WAYNFLETE LOWER SCHOOL - ADDENDUM #4 [post bid]

date: Friday, March 31, 2017
project: Waynflete Lower School Addition & Renovations, 2013-0050
prepared by: Austin Smith Scott Simons Architects
to: Cordelia Pitman Wright Ryan Construction
Rick Bergeron Wright Ryan Construction
Luke Dione Wright Ryan Construction
Anne Hagstrom Waynflete School
Patrick Boure Waynflete School
Phil LaClaire PML Project Management

Subject: Addendum #4 to Bid Documents of January 12, 2017

6 NORTH ELEVATION: FOUNDERS
SCALE: 1/8" = 1'-0"

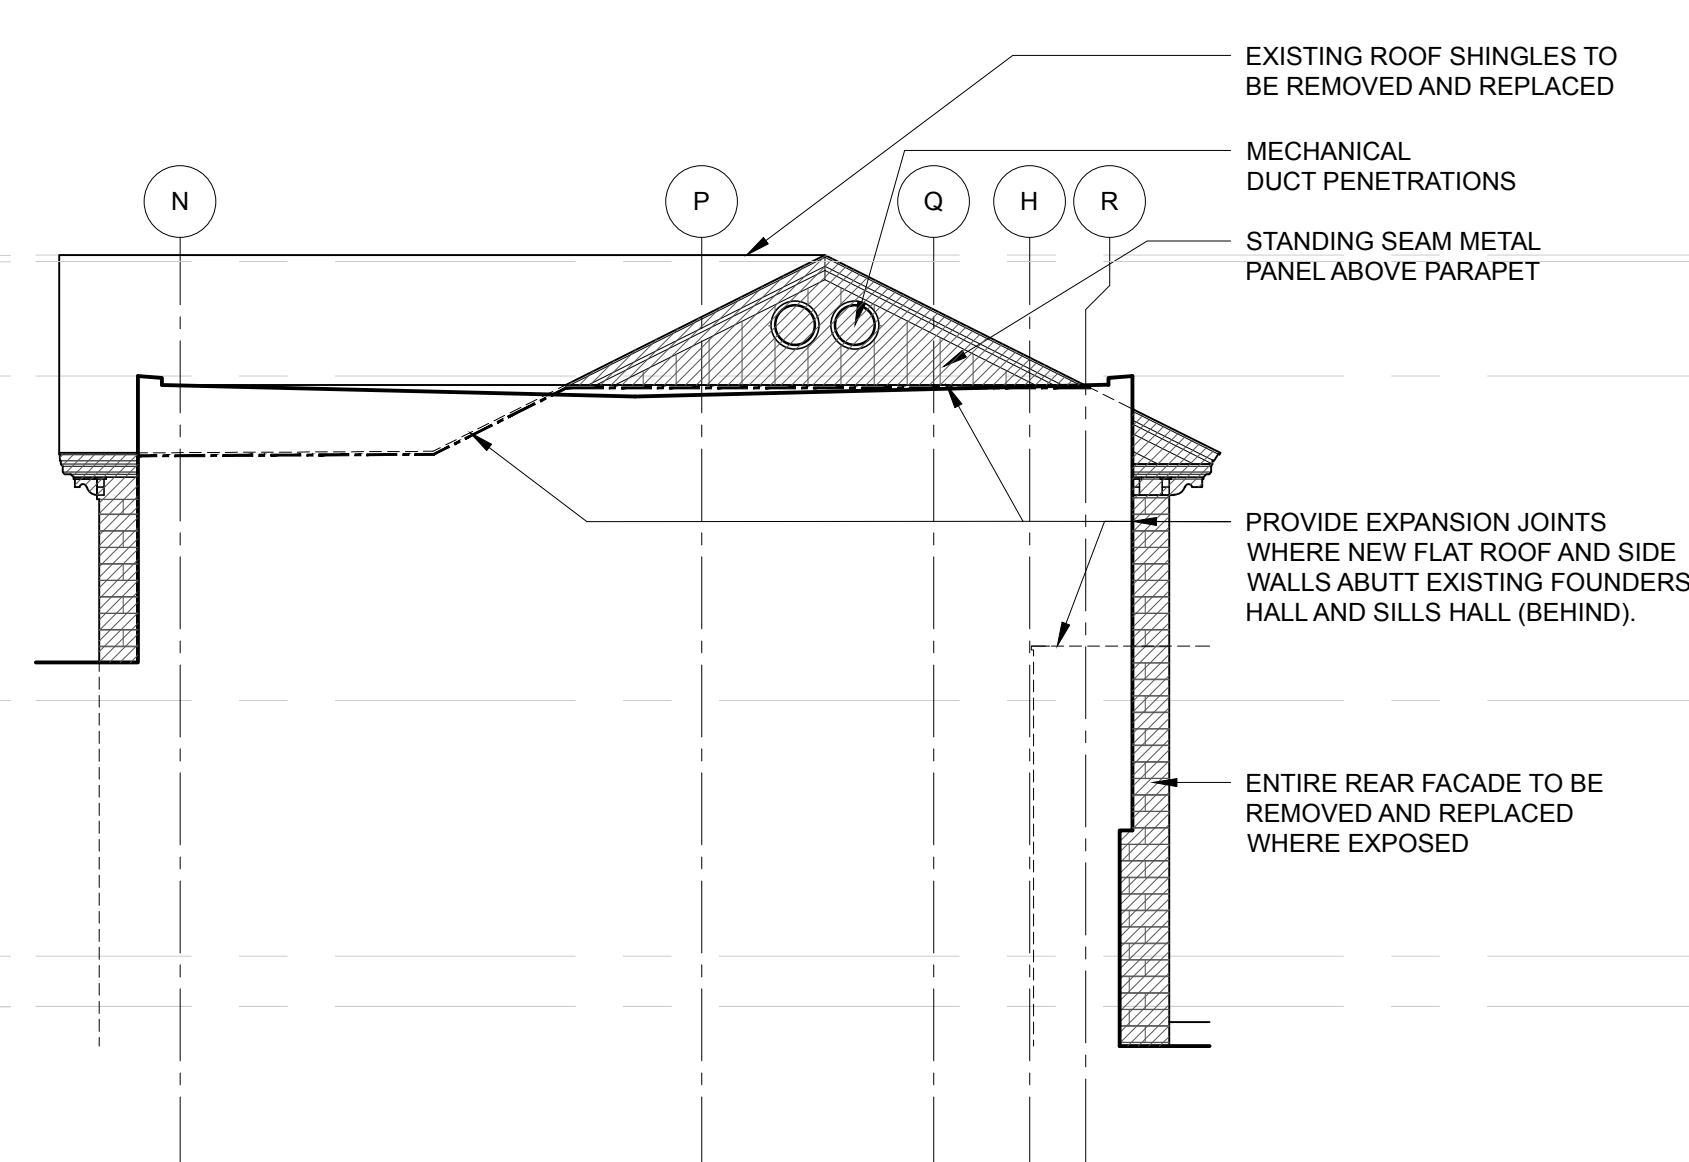
- 4-Q12 Question 12 Q: Please clarify extent of battery powered shades.
A: Please see SKA-09, Motorized Shade Clarification.
- 4-Q13 Question 13 Q: Please clarify requirement for wood strapping at fiber cement panels.
A: Per James Hardie Product Data, "the fastener chosen must be fully encompassed by a wood substrate - the furring may count as all or part of the necessary penetration if it has been proven that the furring and/or wood substrate has the same or better holding power as a timber stud." See manufacturer's recommendation for fastener depth.
